EAST PARK ENERGY

Schedule of Changes to the Draft Development Consent Order

Document Reference: EN010141/DR/8.2

Version P06

- Order Limits
- Land Excluded from Order Limits
- Existing Public Right of Way
- Temporary prohibition or restriction of use of public right of way
(Refer to Schedule 6 of the draft DCO [EN010141/DR/3.1])

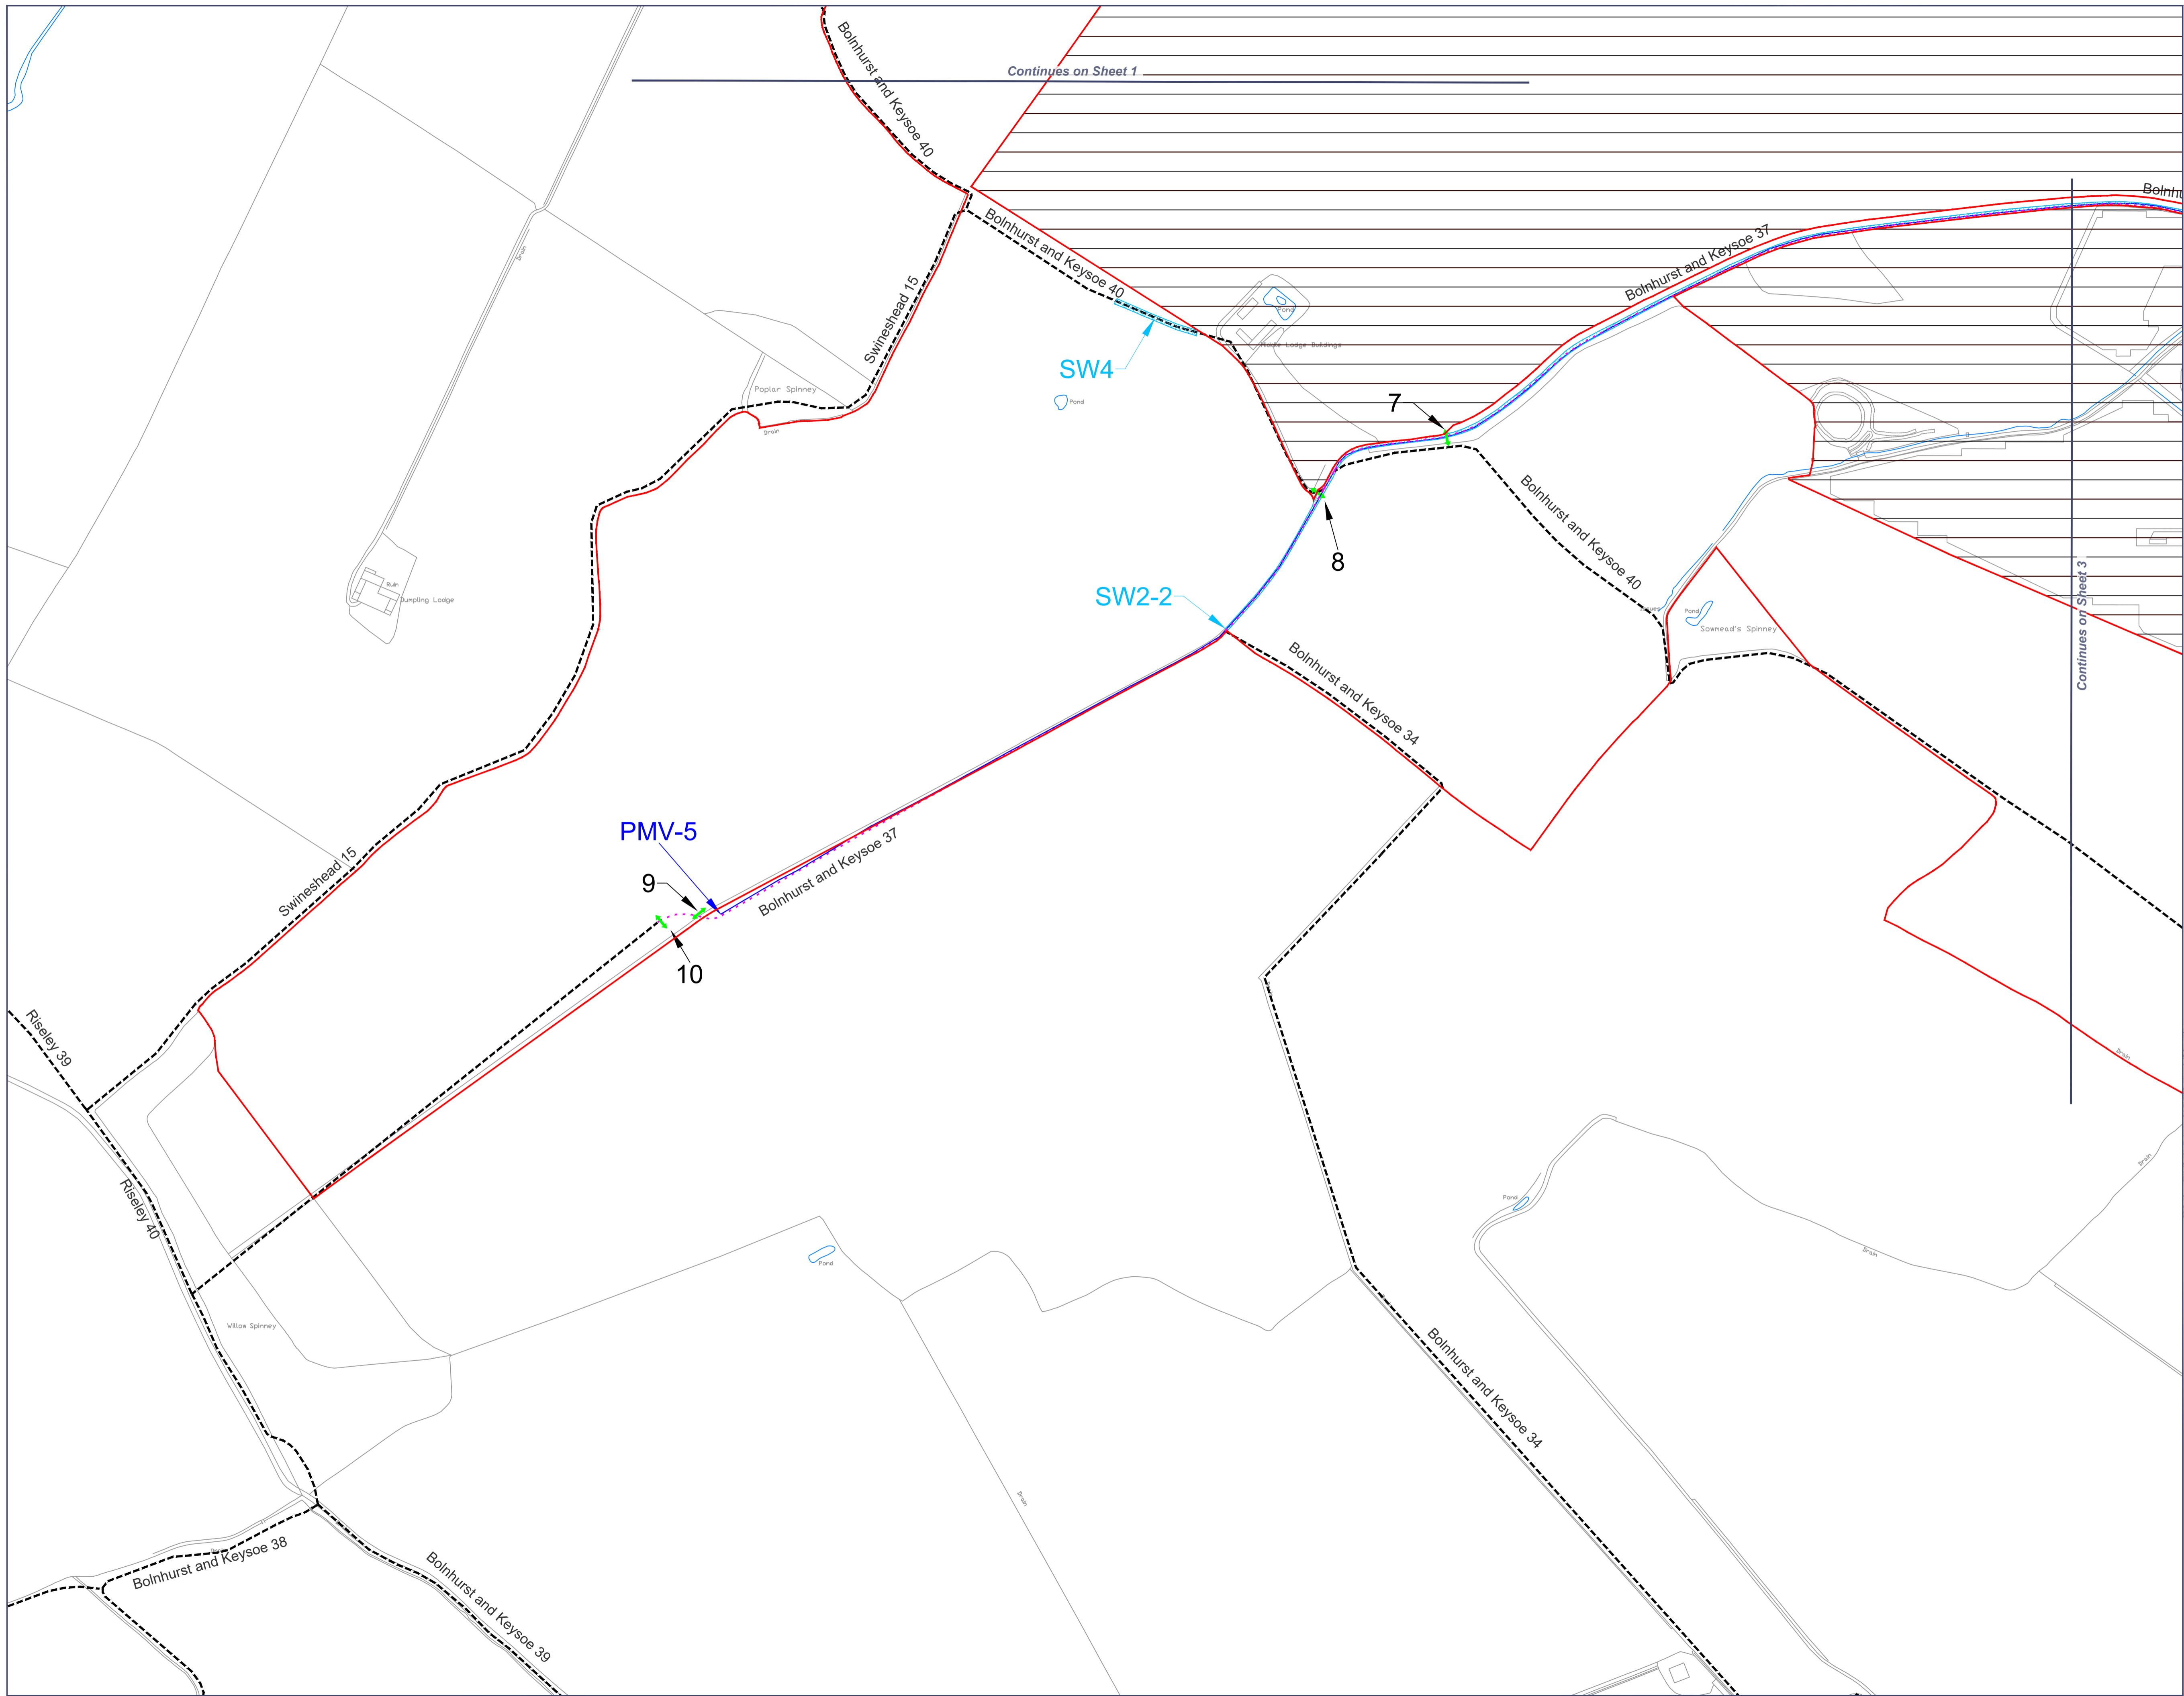
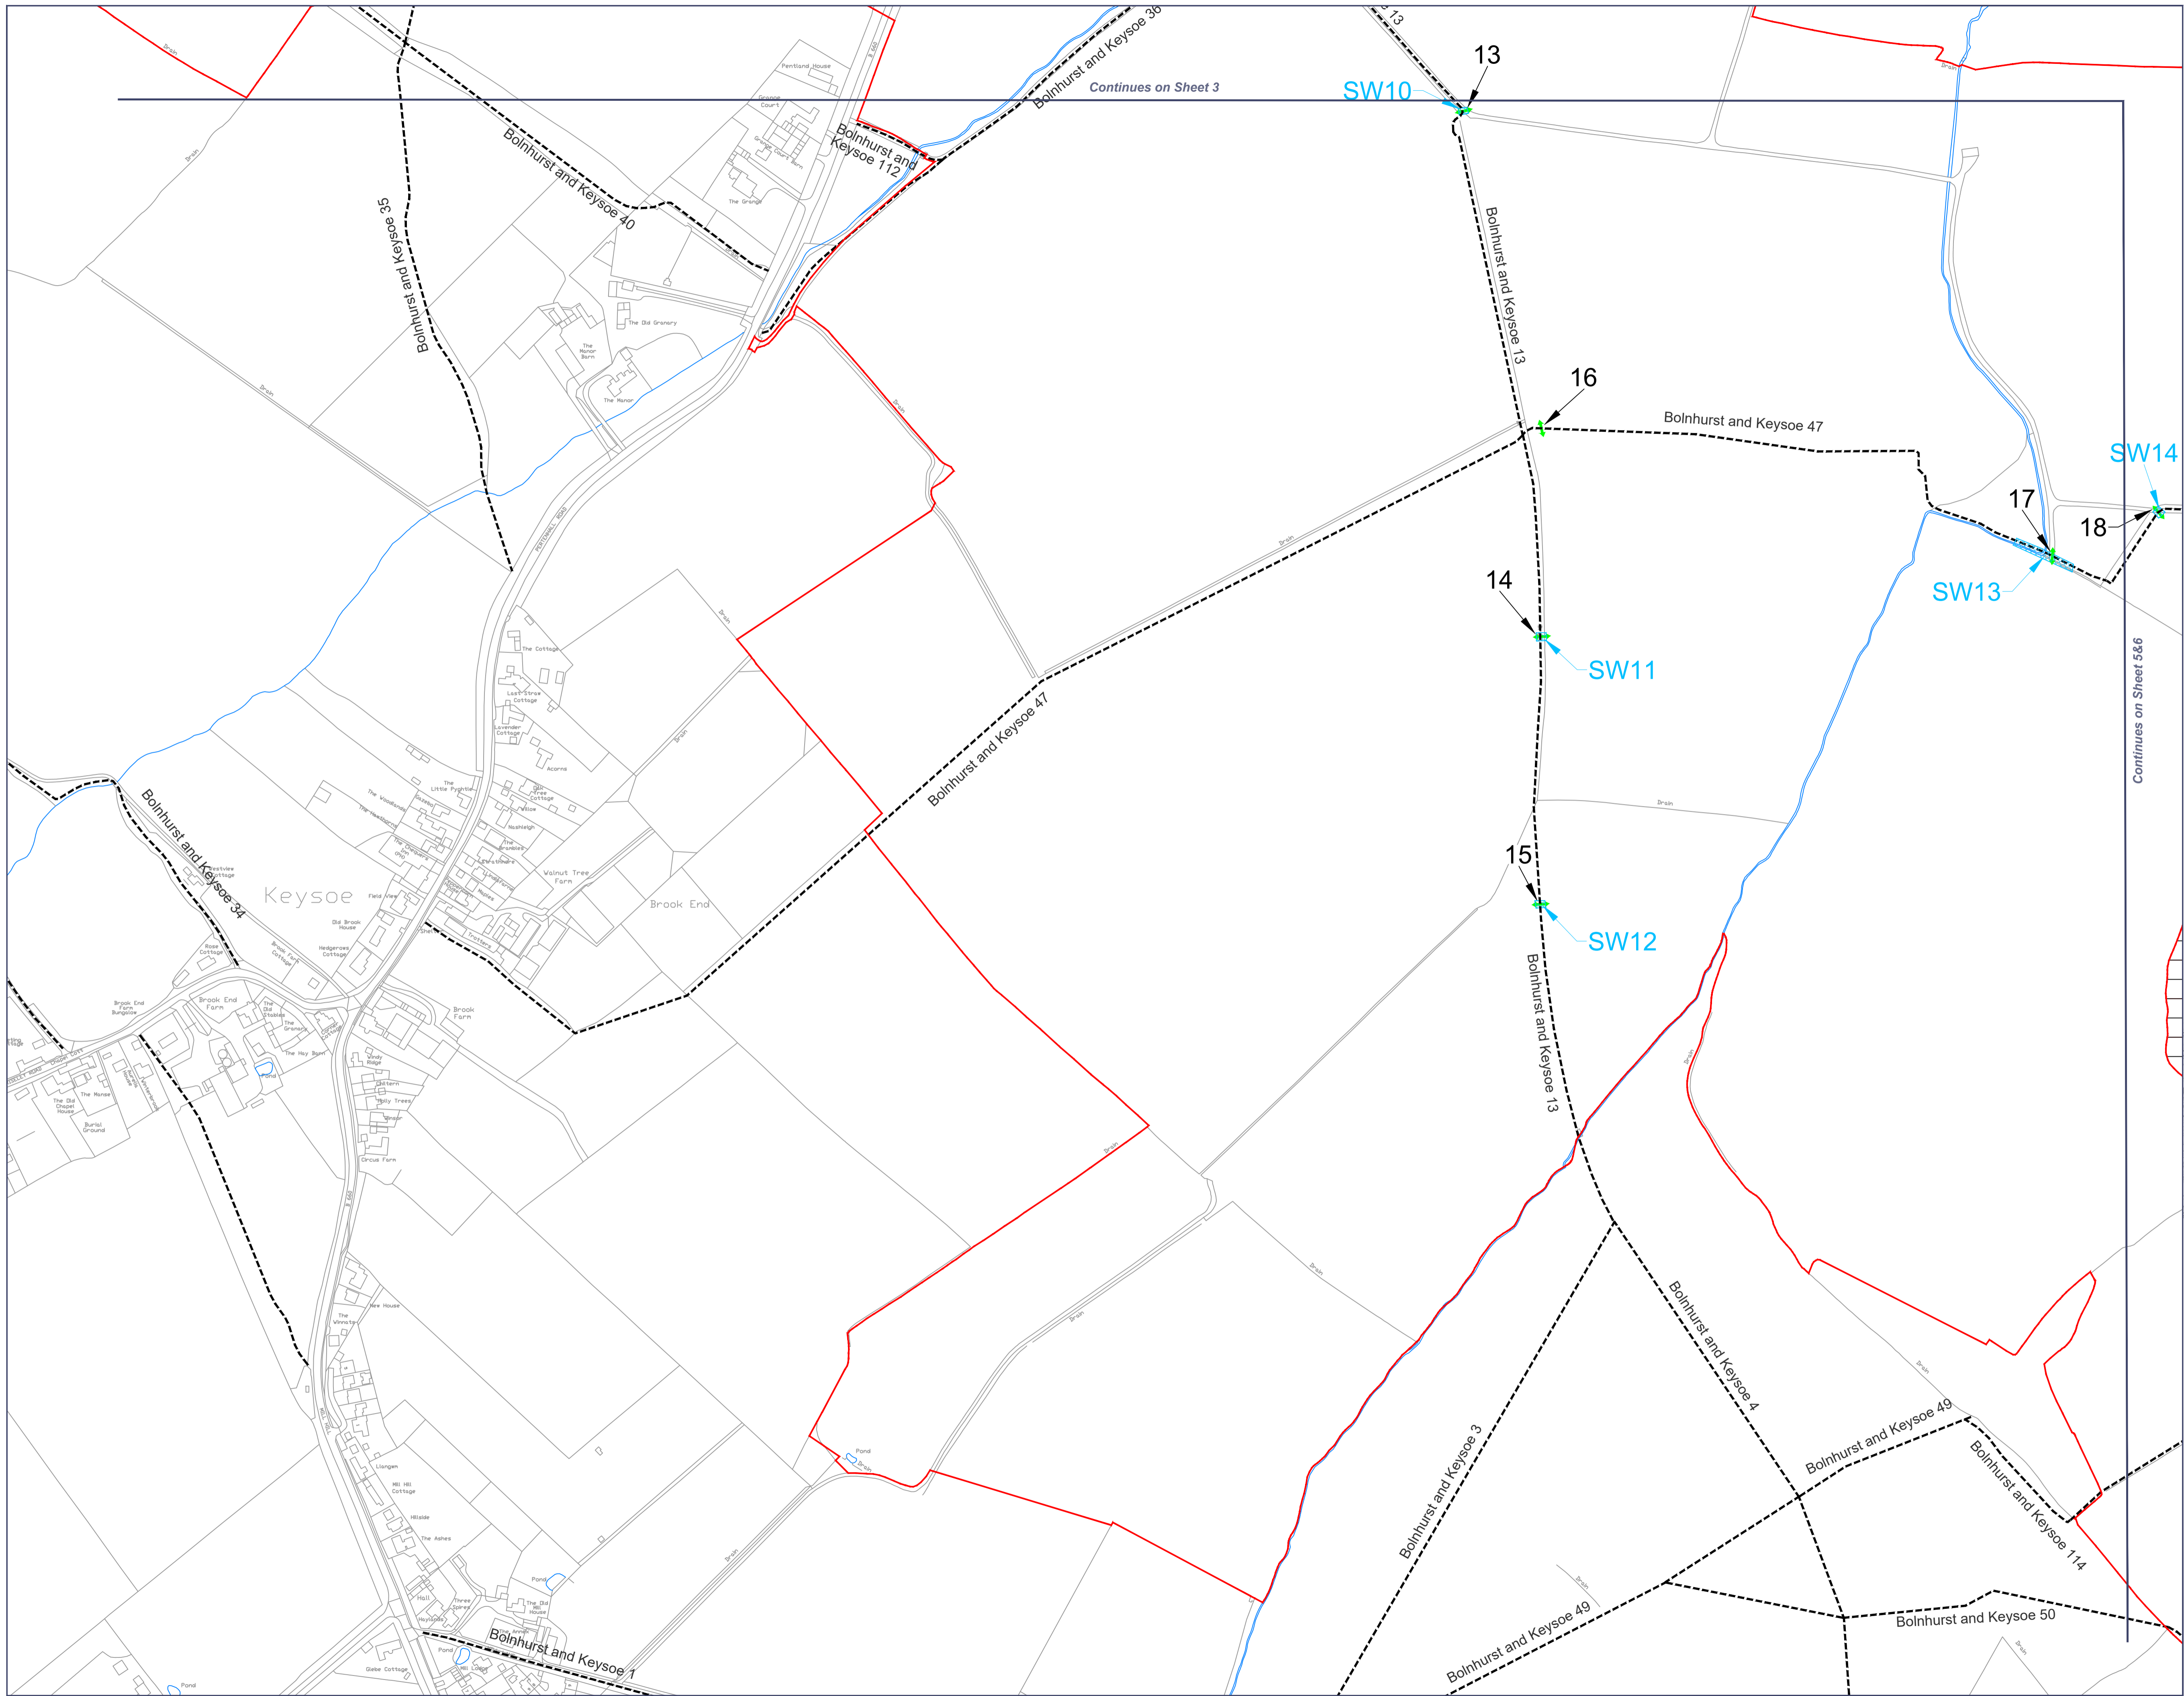
Article / Paragraph / Schedule	Amendment	Reason			
		traffic management plan in accordance with National Highways' relevant representation [RR-904] .			
Schedule 4, Streets subject to street works	A new column (4) has been added listing the relevant highway authority / authorities in relation to each of the streets referenced in the Schedule.	This amendment has been made at the request of Cambridgeshire County Council in their relevant representation [RR-150] .			
Schedule 6, Part 1, Temporary alteration, prohibition, diversion or restriction of the use of streets and public rights of way	Column (2) of the table has been amended as follows: <table border="1"> <tr> <td><i>Pertenhall</i></td><td><i>Public Right of Way – Pertenhall 29 Bridleway Footpath</i></td><td><i>Temporary management including temporary stopping up over the public right of way comprising a length of 455m between the point marked 1 on sheet 1, and the point marked 2 on sheets 1 and 3 of the streets, public rights of way and access plans.</i></td></tr> </table> "Public Right of Way – Pertenhall 29 Bridleway Footpath"	<i>Pertenhall</i>	<i>Public Right of Way – Pertenhall 29 Bridleway Footpath</i>	<i>Temporary management including temporary stopping up over the public right of way comprising a length of 455m between the point marked 1 on sheet 1, and the point marked 2 on sheets 1 and 3 of the streets, public rights of way and access plans.</i>	Correction of typographic error.

<i>Pertenhall</i>	<i>Public Right of Way – Pertenhall 29 Bridleway Footpath</i>	<i>Temporary management including temporary stopping up over the public right of way comprising a length of 455m between the point marked 1 on sheet 1, and the point marked 2 on sheets 1 and 3 of the streets, public rights of way and access plans.</i>			
Schedule 6, Part 2, Authorising permanent use of	A new row has been added to the table as follows: <table border="1"> <tr> <td><i>Pertenhall</i></td><td><i>Public Right of Way – Pertenhall 2 Footpath</i></td><td><i>Motor vehicles authorised by the undertaker may pass along or cross the length of the public right of</i></td></tr> </table>	<i>Pertenhall</i>	<i>Public Right of Way – Pertenhall 2 Footpath</i>	<i>Motor vehicles authorised by the undertaker may pass along or cross the length of the public right of</i>	This public right of way was incorrectly omitted from the draft

Article / Paragraph / Schedule	Amendment			Reason
motor vehicles on public rights of way			<i>way between the point marked PMV-1 on sheet 1 and the point marked PMV-2 on sheets 1 and 3 of the streets, public rights of way and access plans shown shaded blue.</i>	Development Consent Order.
Schedule 8, Part 2, Temporary Suspension of Weight Restriction	Part 2 of Schedule 8 has been deleted in its entirety. This means that what was Part 3 of Schedule 2 is now Part 2.			This Schedule has been removed as the temporary suspension of the weight restriction is no longer required. Please see comments above in relation to Article 17 (traffic regulation measures).
Schedule 13, Part 3, Paragraph 18, For the protection of the drainage authorities	The definition of “specified works” at paragraph 18 has been updated as follows: ““specified work” means so much of any work or operation authorised by this Order as is in, on, under, over or within the watercourse 16 metres of a drainage work or is otherwise likely to— (a) affect any drainage work or the volumetric rate of flow of water in or flowing to or from any drainage work; (b) affect the flow, purity, or quality of water in any watercourse; or (c) affect the conservation, distribution or use of water resources.”			This amendment has been made at the request of Cambridgeshire County Council in their relevant representation [RR-150].
